Comments for Planning Application 21/00255/FUL

Application Number: 21/00255/FUL

Address: 28 St Martin's Road Oxford OX4 4RS

Proposal: Change of use of dwellinghouse (Use Class C3) to a House in Multiple Occupation (Use Class C4)

Drawing Number
444SM-PLA- 001

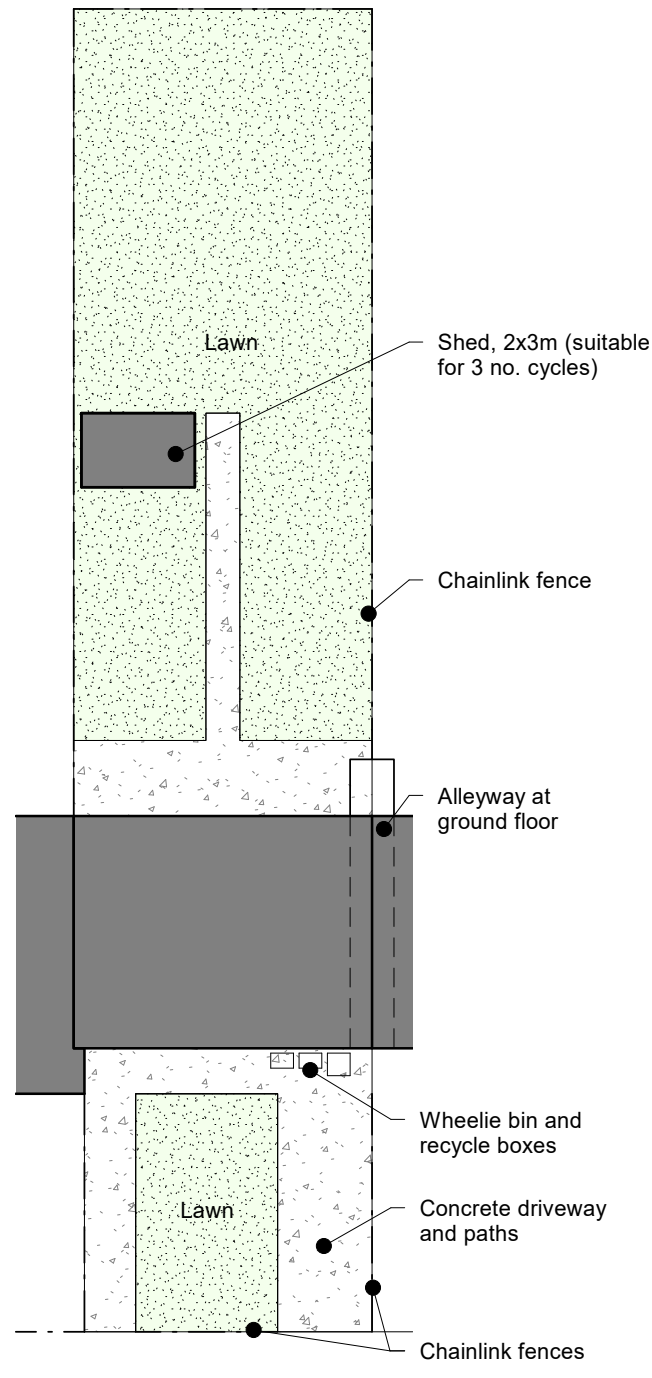
Cycle Parking - The property has a shed suitable for 3+ cycles. This conforms to 2036 Local Plan policy.

Car Parking - The existing dwelling provides one off-street parking space. No additional bedrooms are proposed. The existing provision is considered acceptable for a 3 bed HMO in this location.
